## ***Rezoning Petition Review***

**Date of Review:** November 30, 2020

**Rezoning Petition #:** 20-150

**Location of Property:** Approximately 20.27 acres located along the south side of Alexandriana Rd, north of I-485 and west of I-77.

SCHEMATIC
SITE PLAN

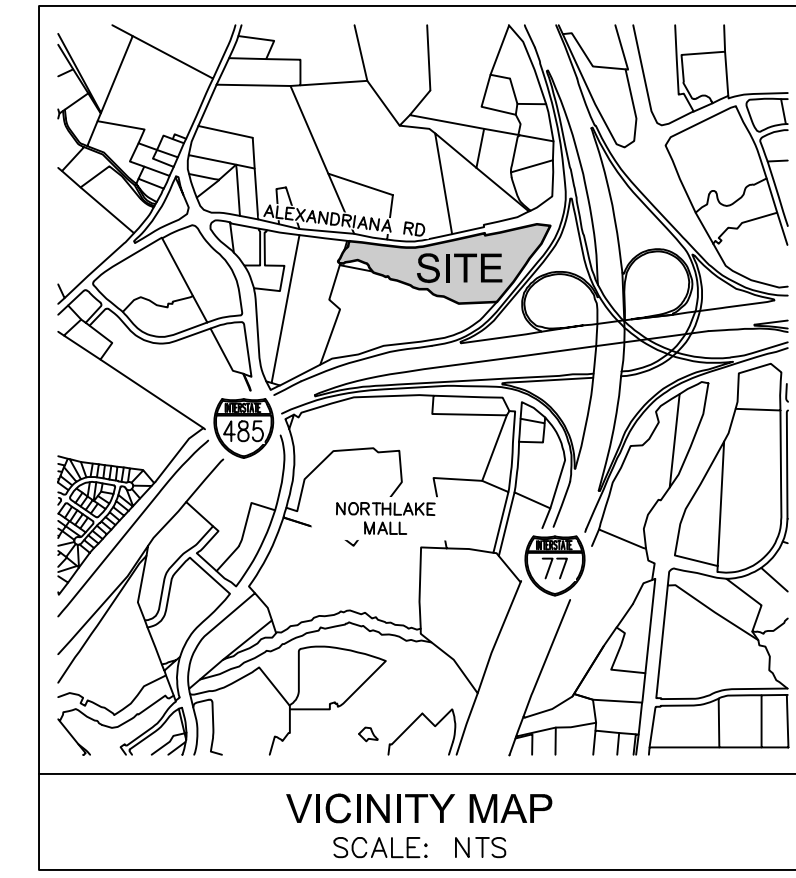
**Recommendations Concerning Storm Water:** Please include the following note under Environmental Features:

*The location, size, and type of storm water management systems depicted on the Rezoning Plan are subject to review and approval as part of the full development plan submittal and are not implicitly approved with this rezoning. Adjustments may be necessary in order to accommodate actual storm water treatment requirements and natural site discharge points.*
